UNTIL SUCH TIME AS THESE DRAWINGS ARE APPROVED BY THE APPROPRIATE REVIEWING AGENCIES, JR ENGINEERING APPROVES THEIR USE. OFFICES DESIGNATED BY WRITTEN AUTHORIZATION. PREPARED FOR SR LAND, LLC 20 BOULDER CRESCENT SUITE 201 COLORADO SPRINGS, CO 80903 JAMES F. MORLEY (719) 471-1742	
J.R. ENGINEERING A Westman Company Centennial 300-740-9888 • Colorado Springs 719-583-2583 Fort Collins 970-491-9888 • www.jrengineering.com	
BY	DATE
No.	REVISION
H-SCALE	1"=50'
V-SCALE	1"=5'
DATE	07/17/23
DESIGNED BY	CWC
DRAWN BY	DUG
CHECKED BY	
VOLLMER ROAD (BARBARICK) -INTERIM CONDITION INITIAL/INTERIM GESC	
SHEET	2 OF 6
JOB NO.	25188.01

VOLLMER ROAD (BARBARICK)
 -INTERIM CONDITION
 FINAL GESC

VOLLMER ROAD (BARBARICK) -INTERIM CONDITION INITIAL/INTERIM GESC	BY	DATE							
	No.	REVISION							
	H-SCALE	1"=50'							
	V-SCALE	1"=5'							
	DATE	8/23/22							
	DESIGNED BY	CWC							
	DRAWN BY	DUG							
	CHECKED BY								
	SHEET	2	OF	6					
	JOB NO.	25188.01

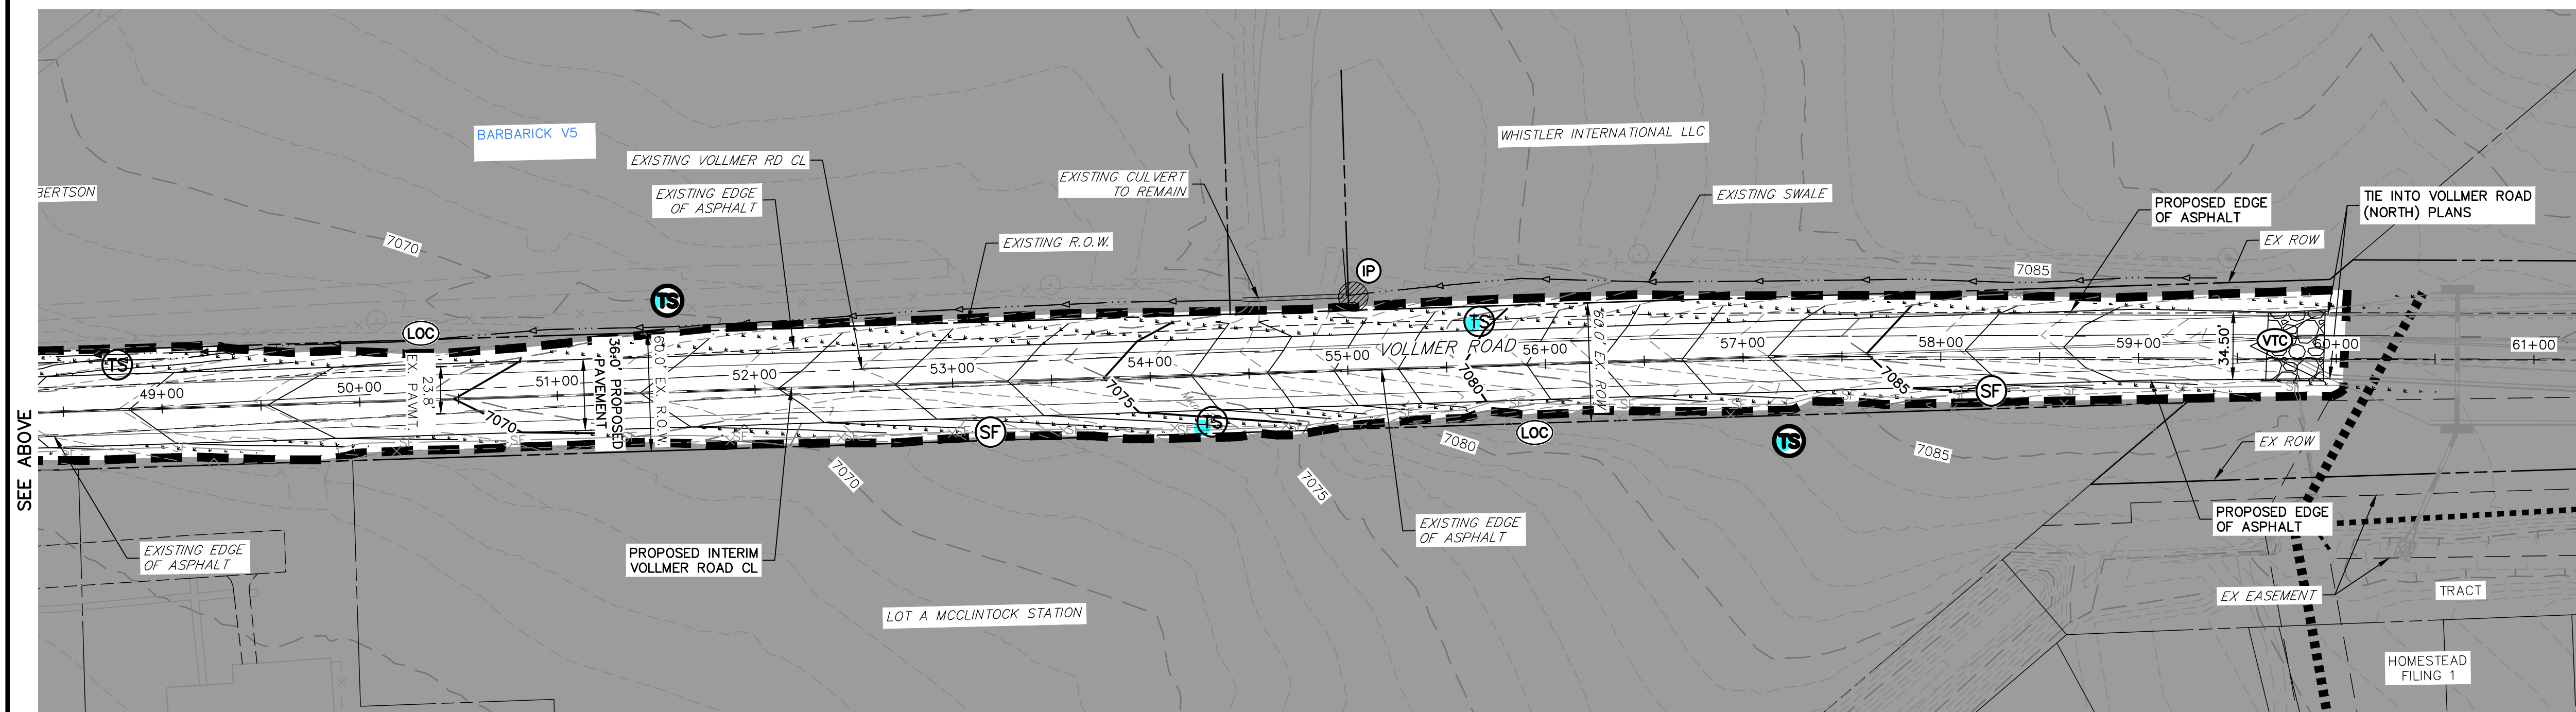
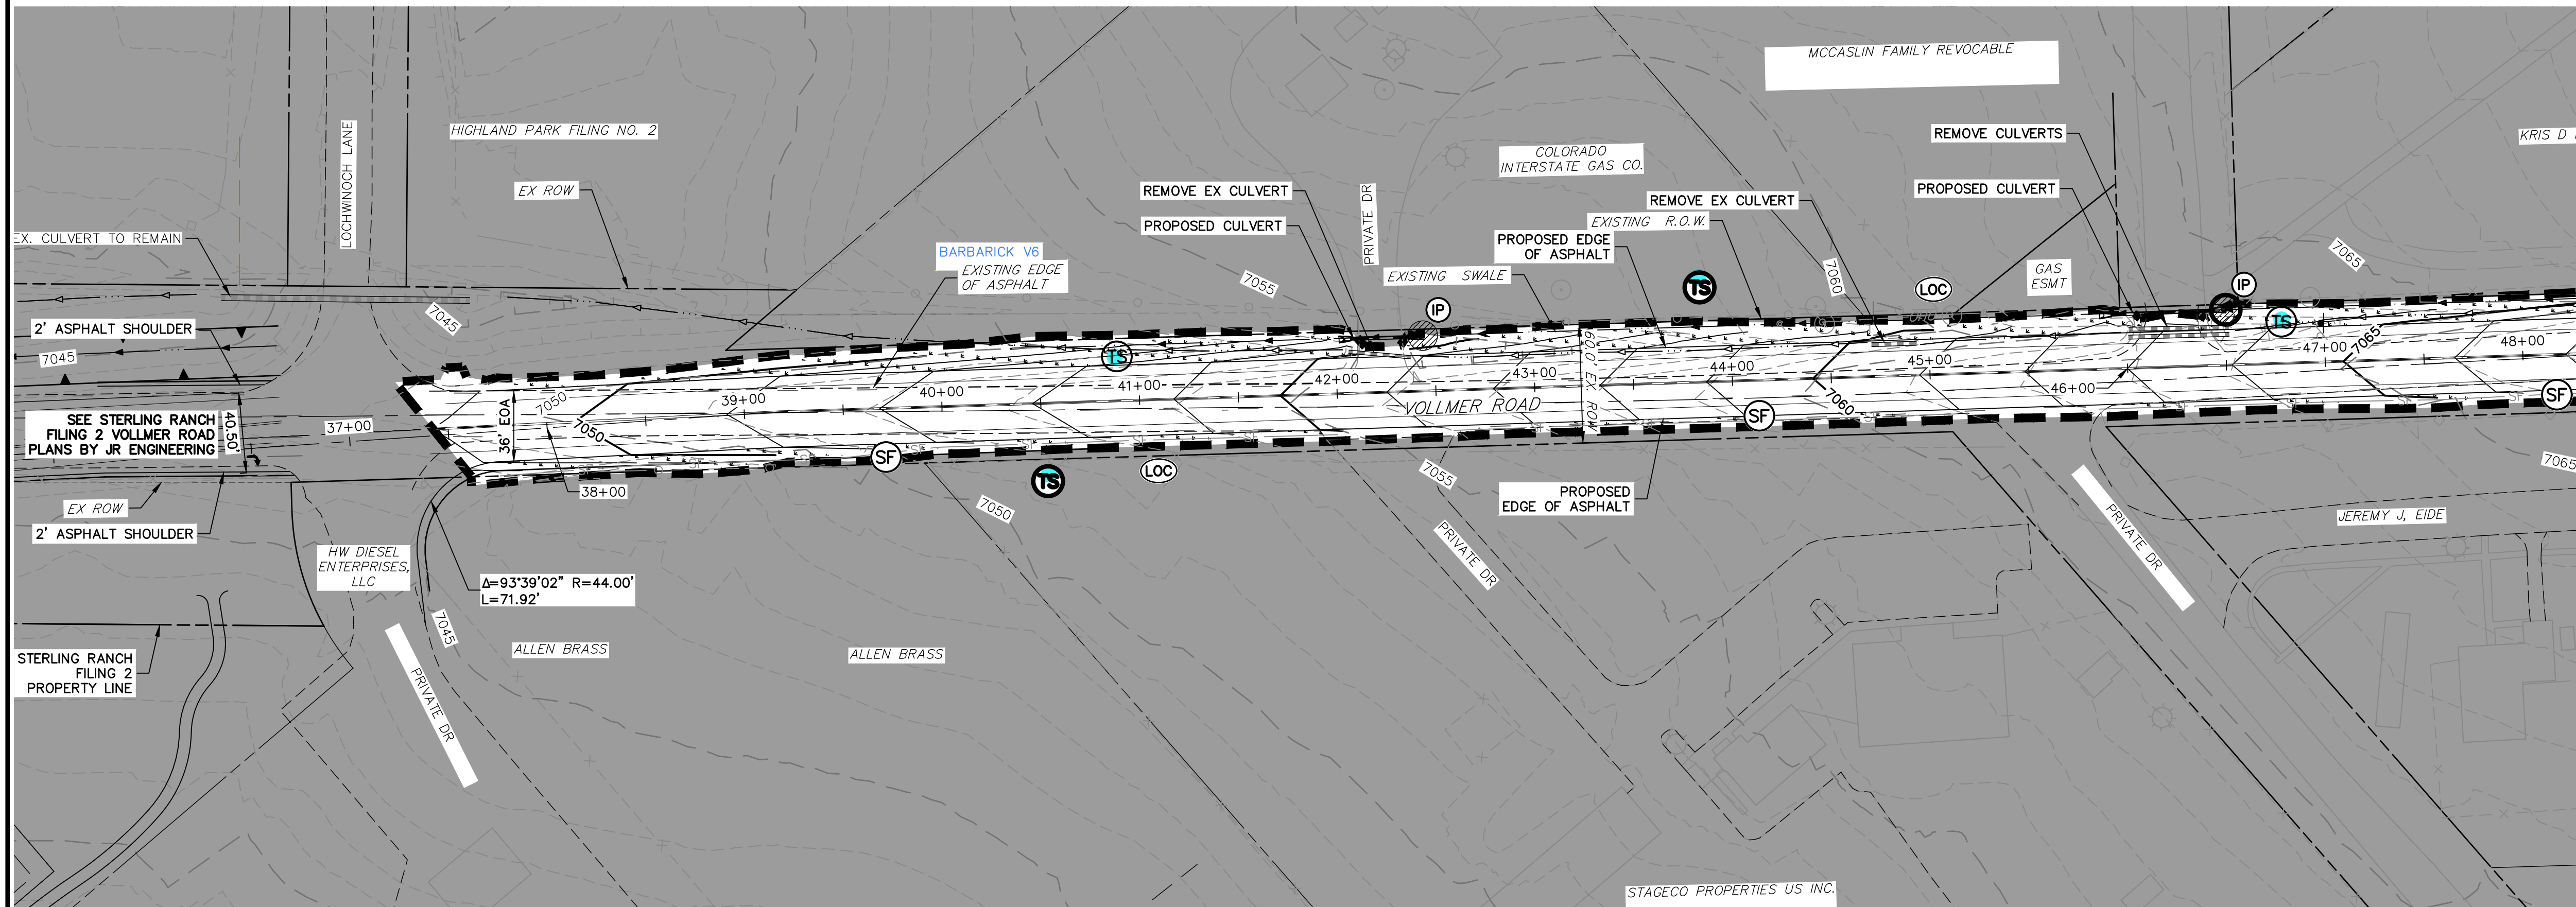
Show easements for off-site grading. Typical comment for all areas that exceed existing R/W and are outside the delineated 10' TG&CE

BMPs should not be outside the limits of construction/disturbance. Adjust LOC limits

GEC Checklist Item g: Show all existing utilities. If no utilities are present add a note to that effect.

JR Response: easements updated for grading and check dams

JR Response: Addressed, LOC updated

JR Response: Existing gas line shown, note added to plans
